KIRKLEES METROPOLITAN COUNCIL INVESTMENT & REGENERATION SERVICE

Reference No:	2024/62/91742/W
Site Address:	23, Rock Fold, Golcar, Huddersfield, HD7 4AD
Description:	Demolition of existing shed and erection of replacement single storey front extension (within a Conservation Area)
Recommending Officer:	Tom Hunt

OFFICER REPORT - 2024/91742 – Demolition of existing shed and erection of replacement single storey front extension (within a Conservation Area).

PROJECT	Proposed Side Extension at 23 Rock Fold, Golcar, Huddersfield HD7 4AD		
CLIENT	Mr S Brook		
DWG TITLE	Floor Plan, Elevations and View		
DWG NO.	2327 - 01	SCALE	As indicated
		DATE	9/06/2024

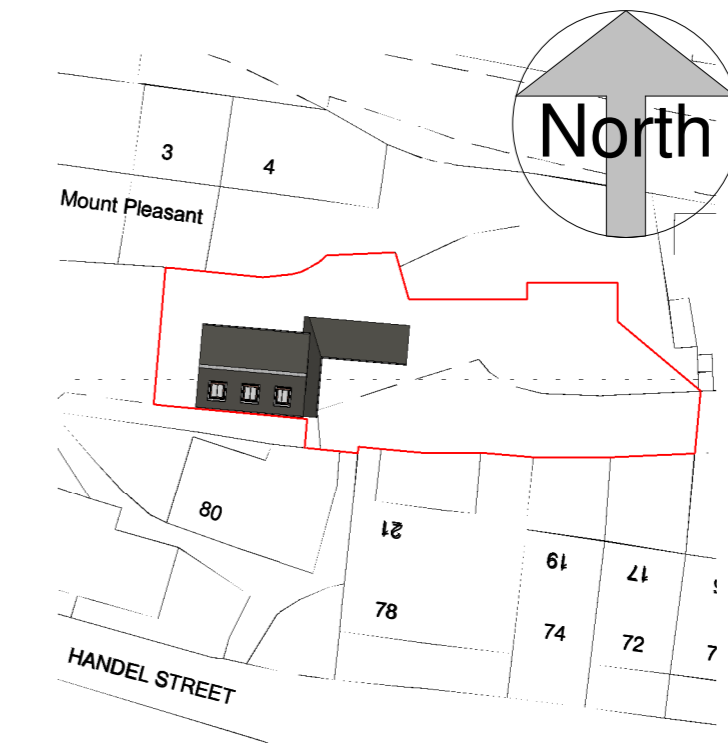
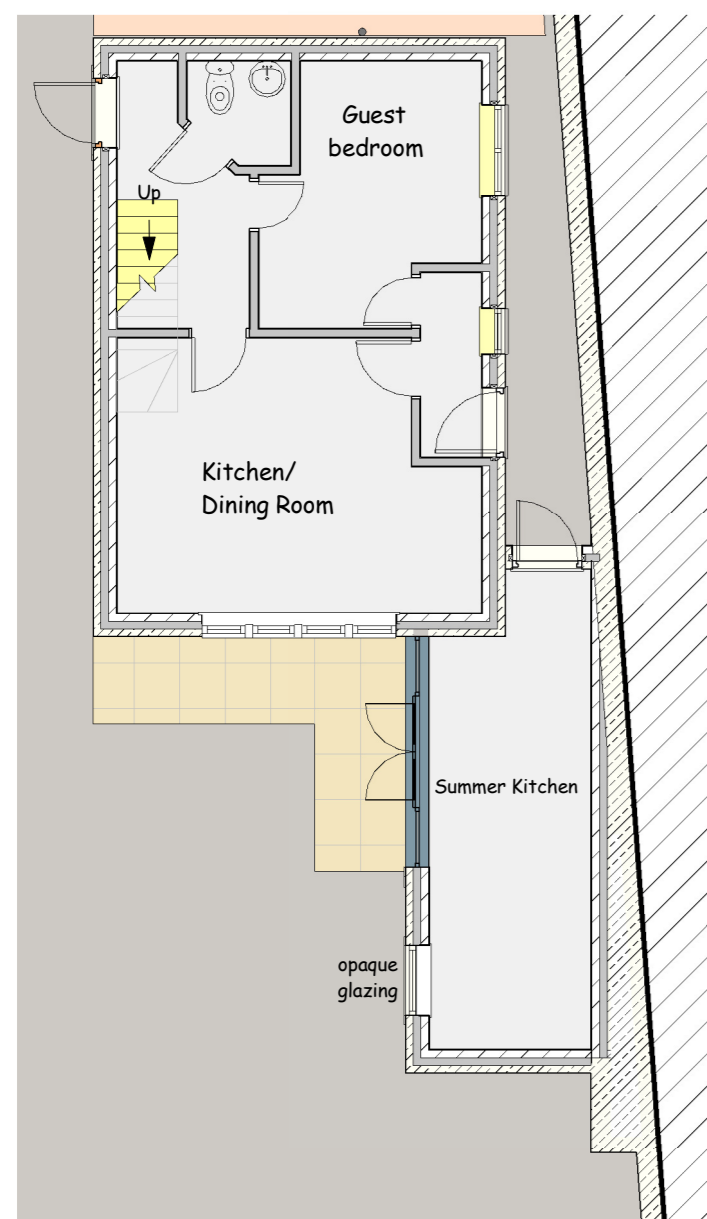
4.1 Retrospective planning permission is sought for the alteration to the single-storey front extension. It would be reduced in width from 7.3m to 6.9m and be of the same depth. Its lean-to roof design would have an overall increase in height from 3m to 3.3m from ground level to be aligned with the existing single-storey front projection; this would have a marginally similar eaves height from ground level. The fenestration and door opening is to remain the same. The materials proposed would be changed from black horizontal cladding and felted roof to natural stone and roofed with tile to match the host.

4.2 The latest submission is an amended proposal to the earlier application, which was refused and subsequently dismissed at appeal. The revised proposal would reduce the width, increase the overall height and face/roof the front extension with matching materials. This would have the effect of reducing the overall visible width of the scheme from 6.2m to 5.7m.

4.4 The proposal would still have an unacceptable level of overlooking and loss of

Privacy to the neighbouring property to the south at no. 21. The Inspector noted that even a condition, to have the opening be non-opening and obscurely glazed, would still given the proximity, remain a perception of loss of privacy for the occupiers of No.21.

4.5 The Inspector considered that even if the materials were altered to be stone and tile to match the host, the scheme's notable long projection relative to its host, and mono-pitched roof – would appear incongruous in the context of the traditional pitched roof cottages on Rock Fold, as well as Mount Street and Handel Street. Its form, and siting results in a building that is unduly prominent and causes harm to the character and appearance of the streetscene, Golcar Conservation Area and to Listed Buildings.
